2021 Financial Assurance Estimate Form
(with pre-plat construction)

PROJECT INFORMATION		
Latigo Trails Fil 10	9/17/2021	SF-XX-XXX
Project Name	Date	PCD File No.

**LATIGO TRAILS - FILING NO. 9**  
**SOUTH POND PLANS**

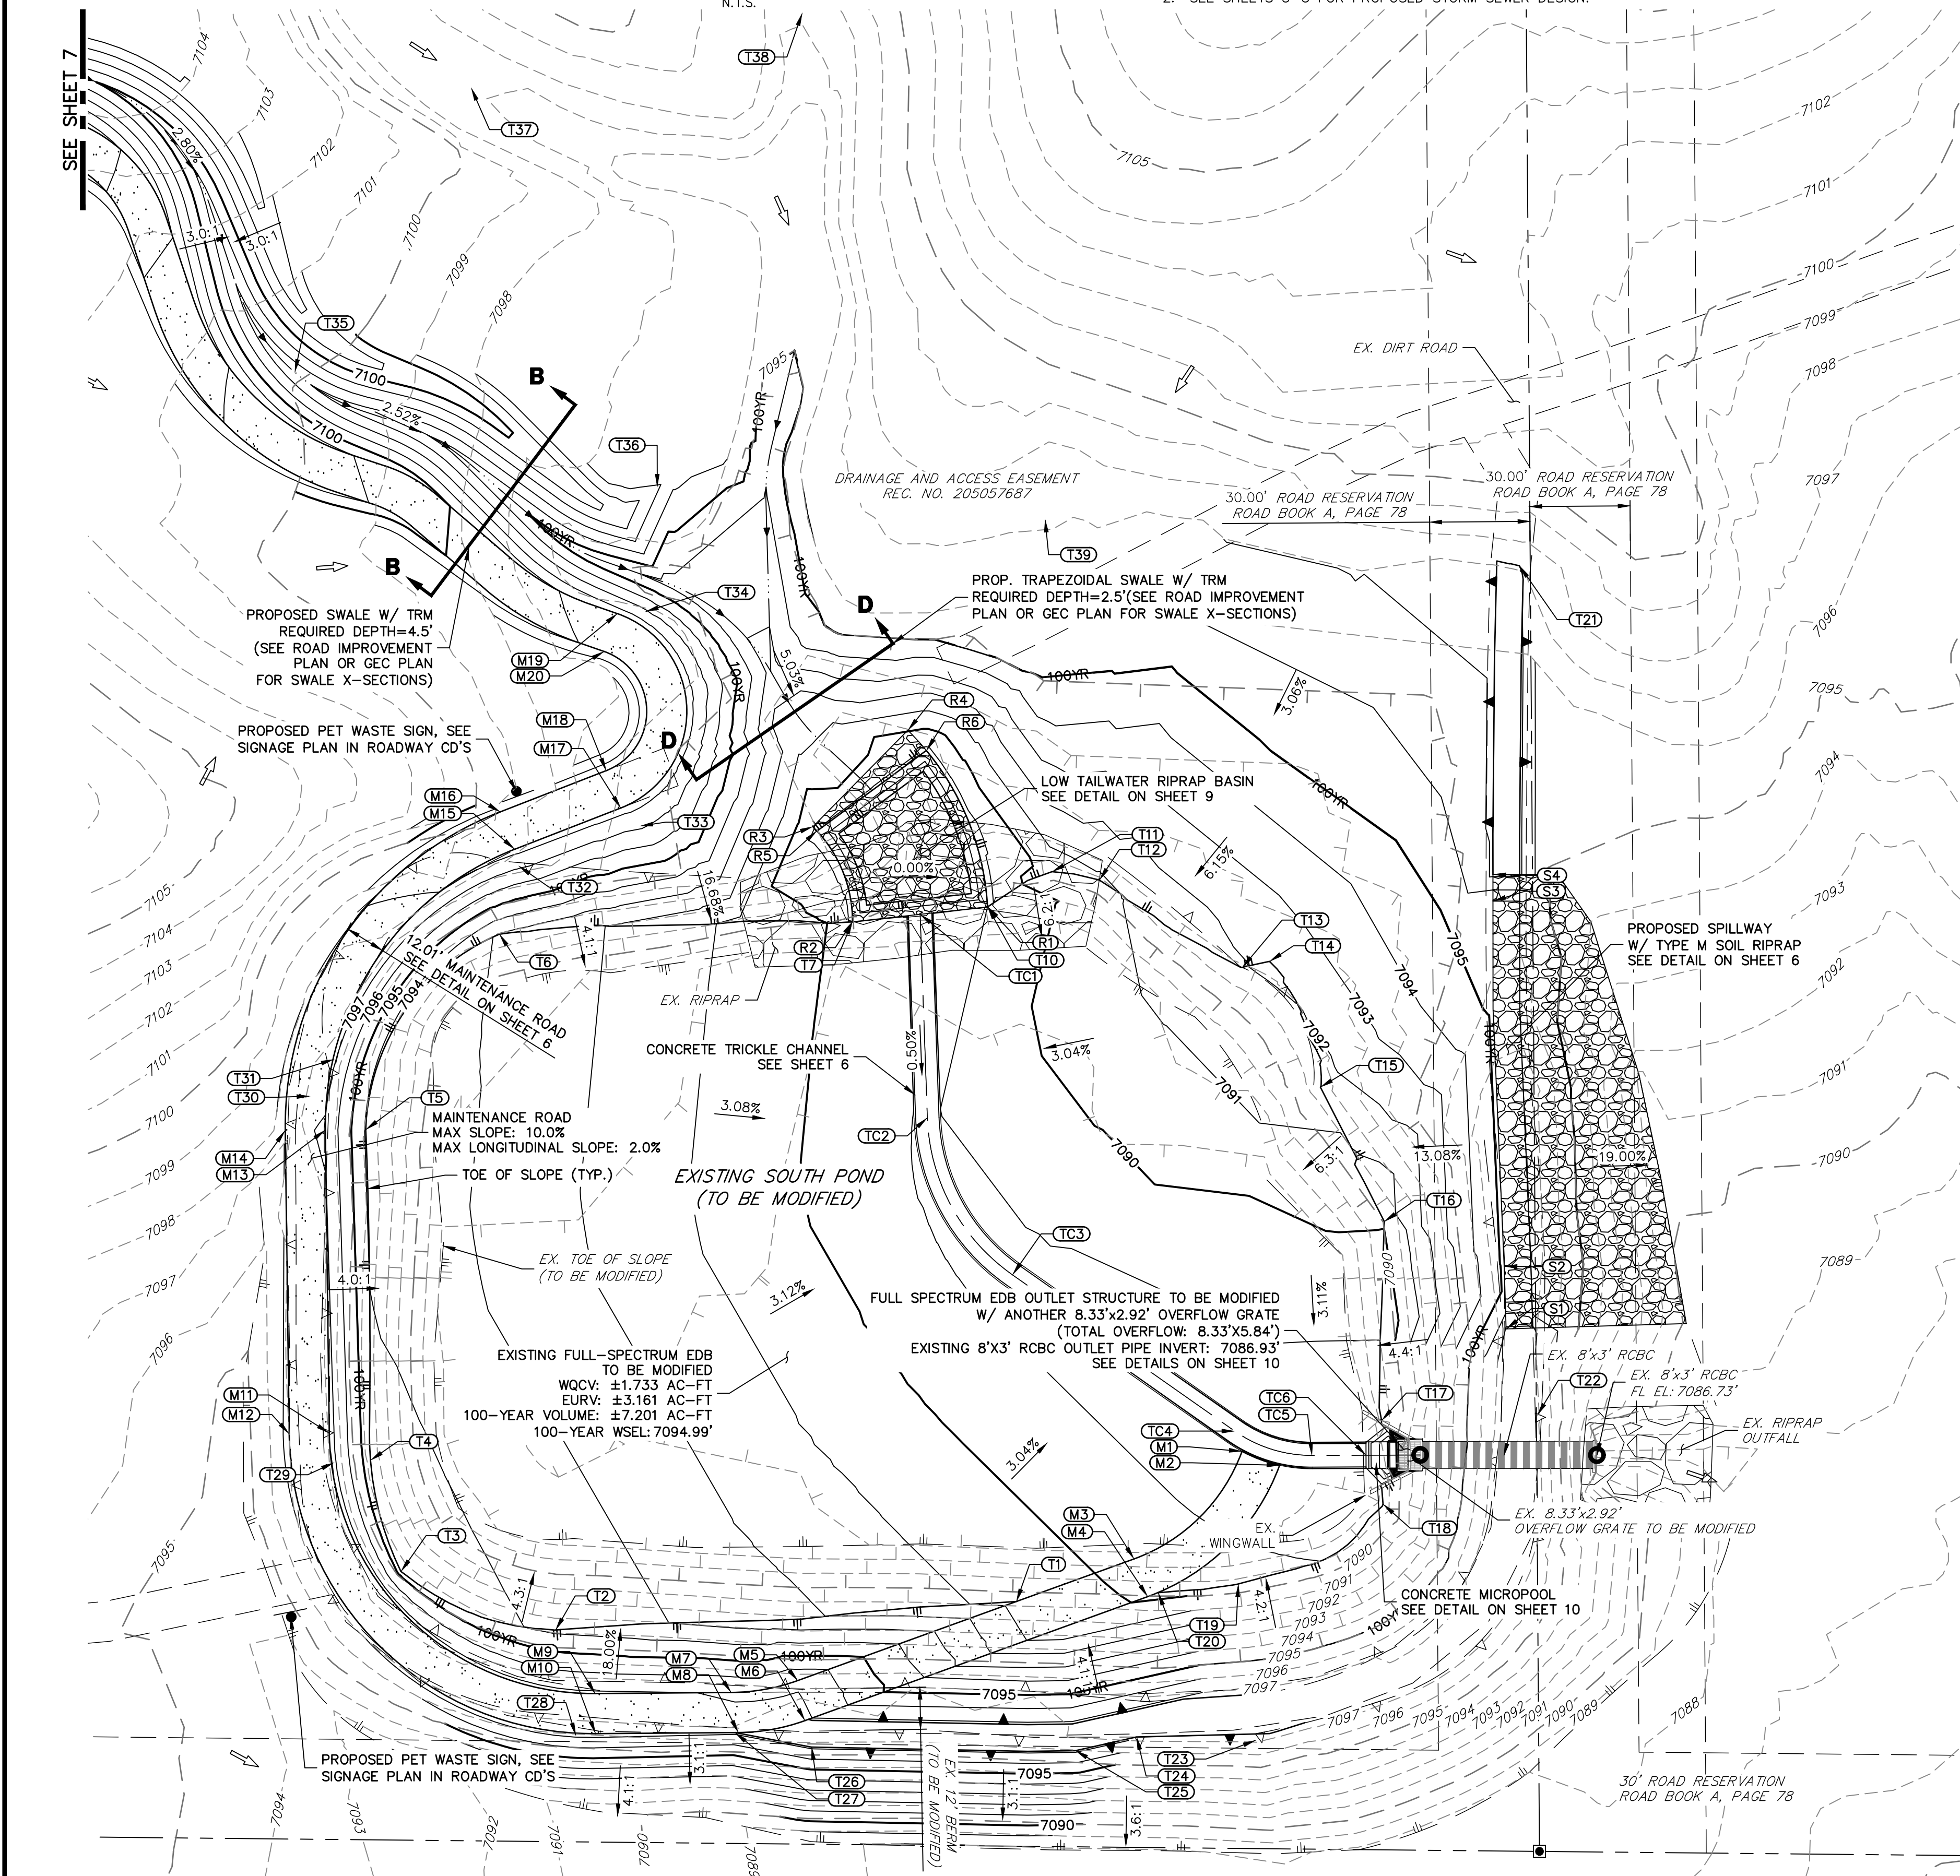
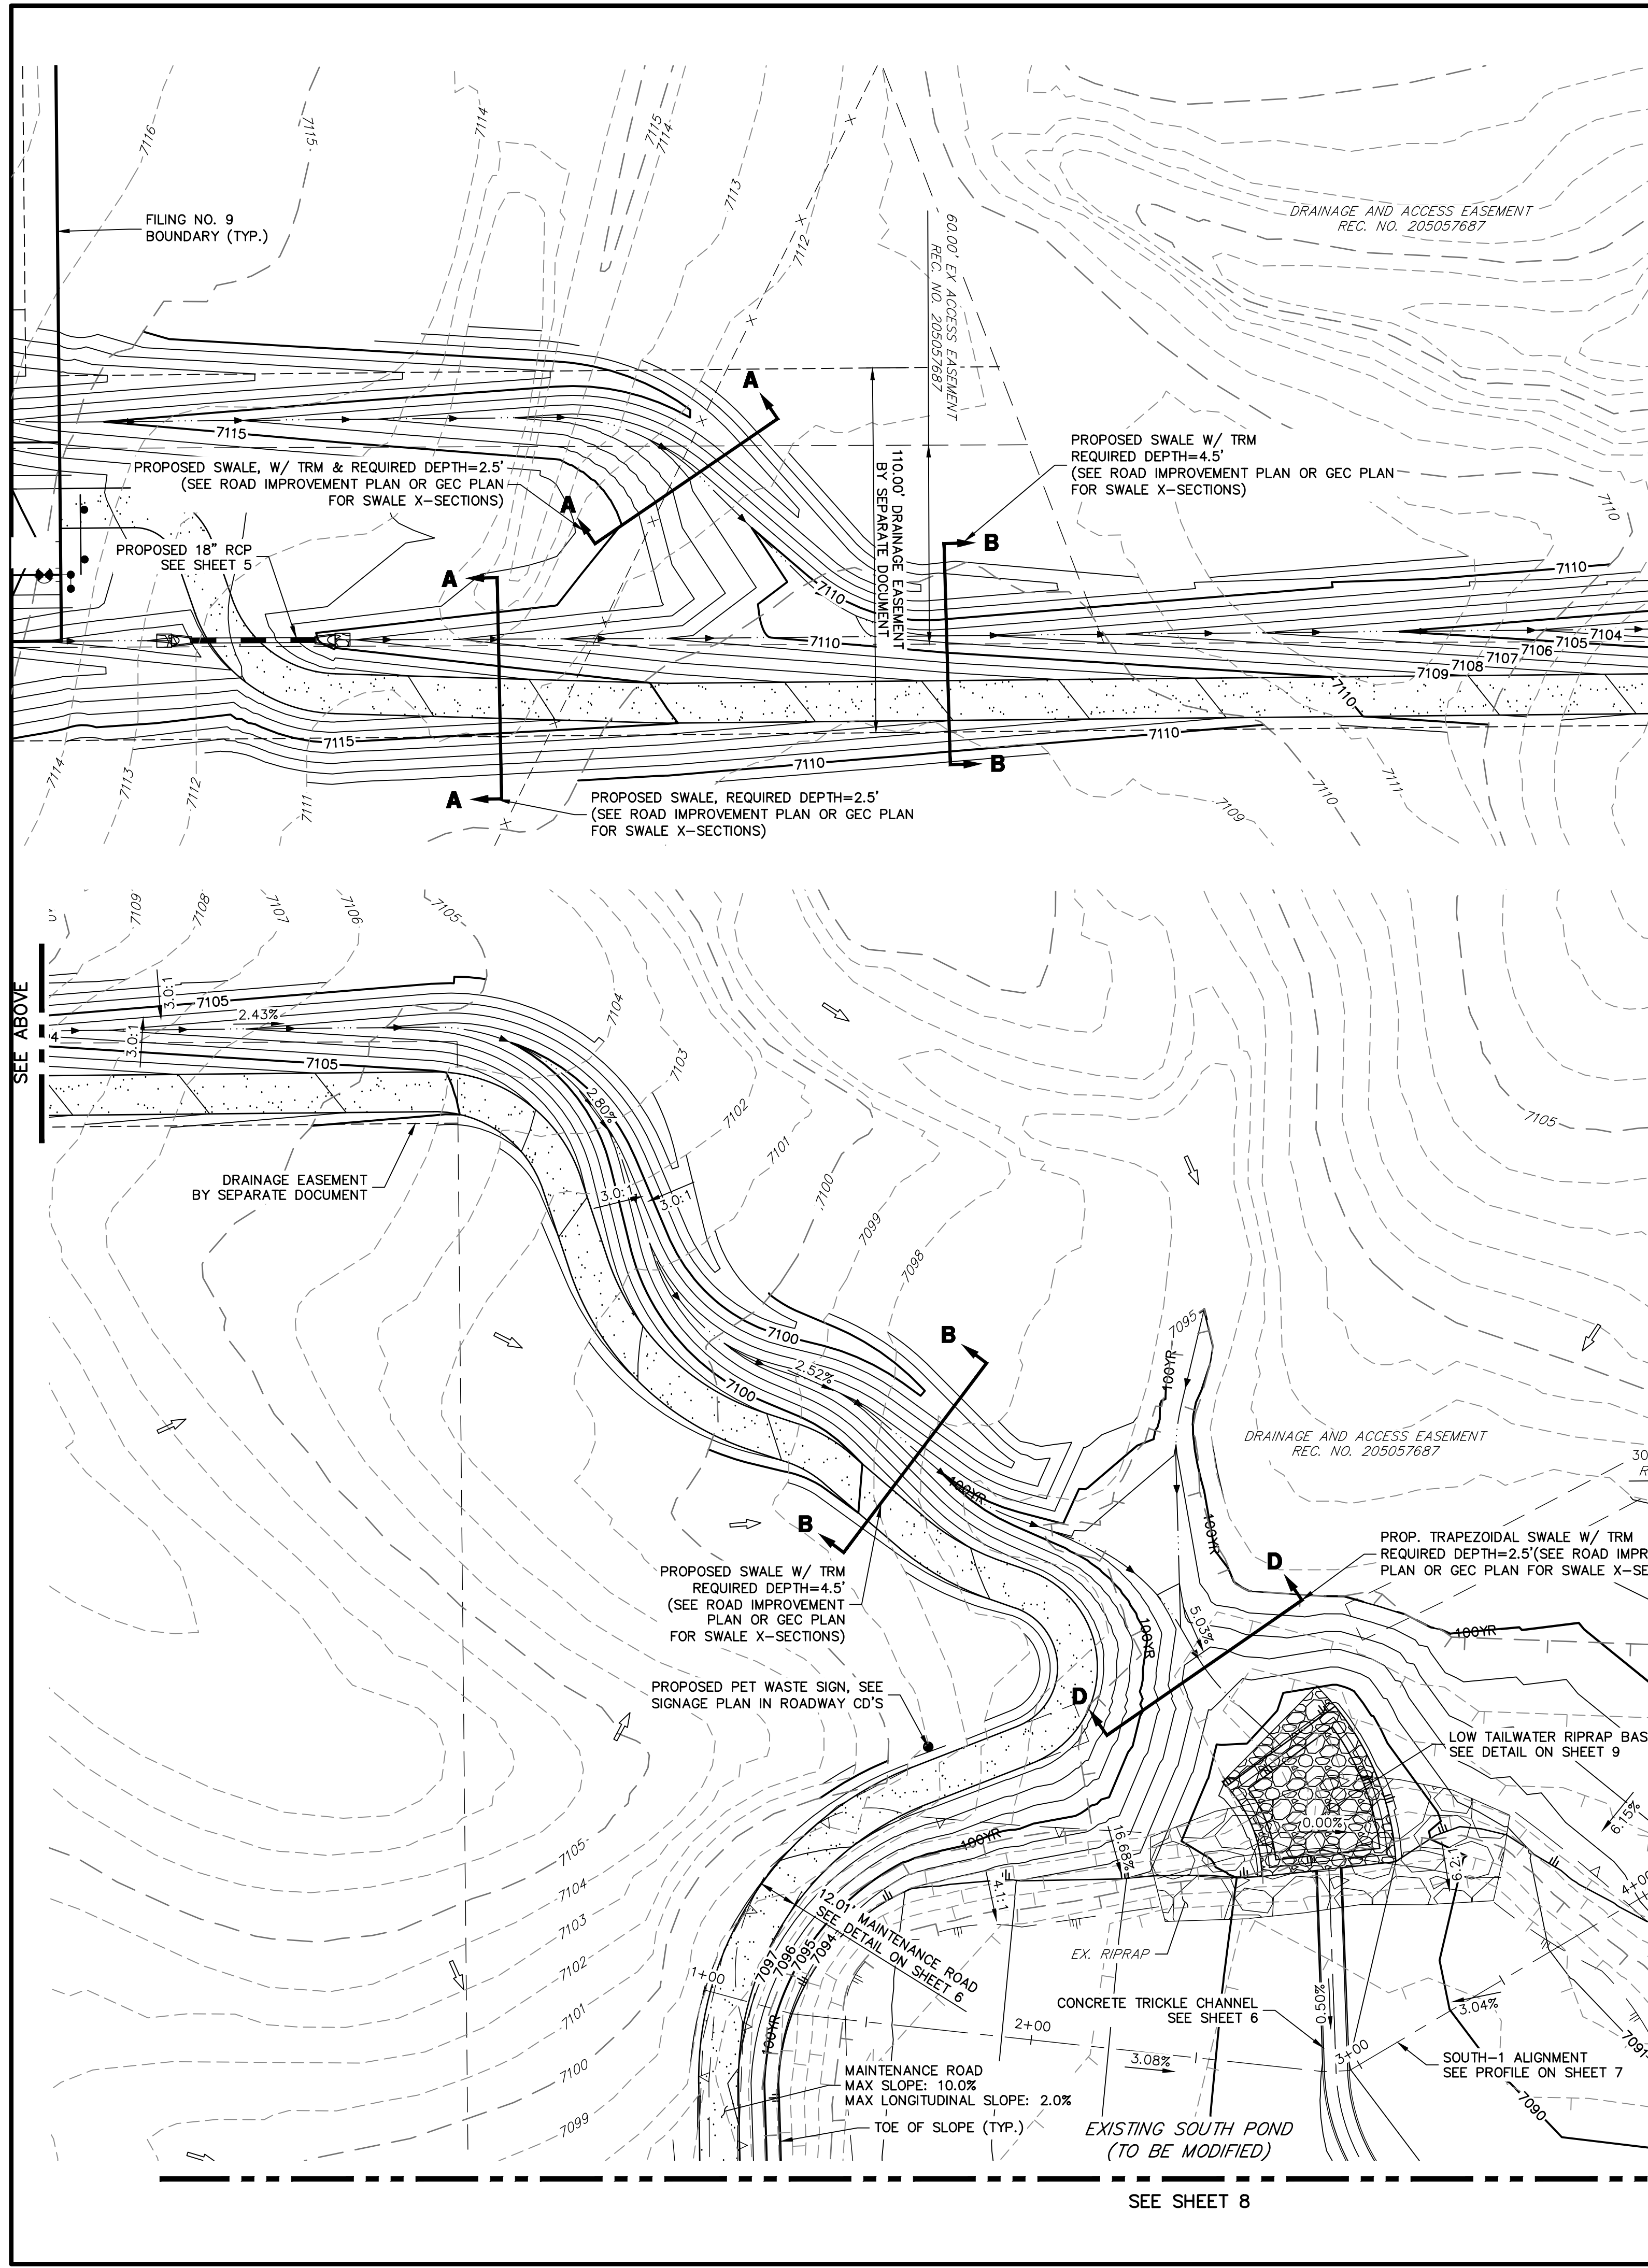
Update pipe quantity per plans

Revise. Pond plans show 30" RCP
